**University of Sydney's Campus Improvement Program 2014-2020 State Significant Development (SSD 6123)**

I am a resident of Darlington and I have been granted an extension until 31 March 2014 to make a submission in regard to the above State Significant Development (SSD) application.

Drawing no:	<b>SSD-D-12</b>	Revision:	-
Date:	29-11-2013		
Drawn by:	CIS		
Checked by:	JC

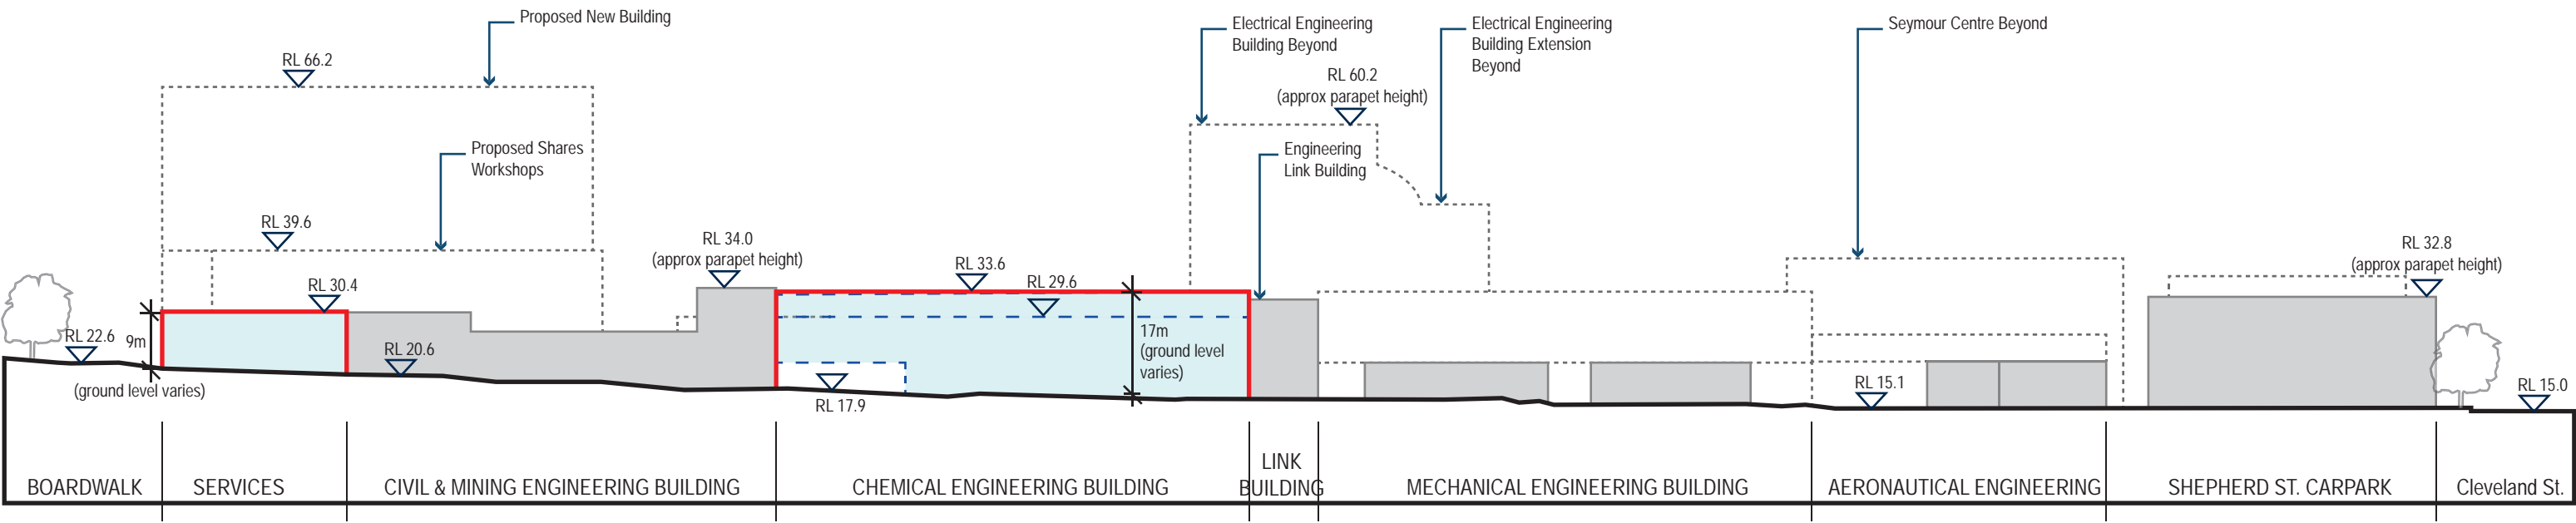
I object to the proposed 3 storey building in Shepherd Street and the "multidisciplinary building" opposite the Sports Centre both of which will overlook residents homes in Shepherd Street, Calder Road, Lander Street, Boundary Street and Abercrombie Street.

I object to the destruction of the Darlington Eucalypt Grove in Shepherd Street and replacing it with a 3 storey building overlooking residents' houses. This is one of the only remaining open spaces on the edge of the Darlington campus and should be retained to provide a green buffer zone between the University and the adjoining residential area.

I object to the proposed Service Centre on Shepherd Street as it will bring heavy, loud vehicles onto a residential street. As it will be positioned on the narrowest part of this street, it will also create a dangerous traffic hazard.
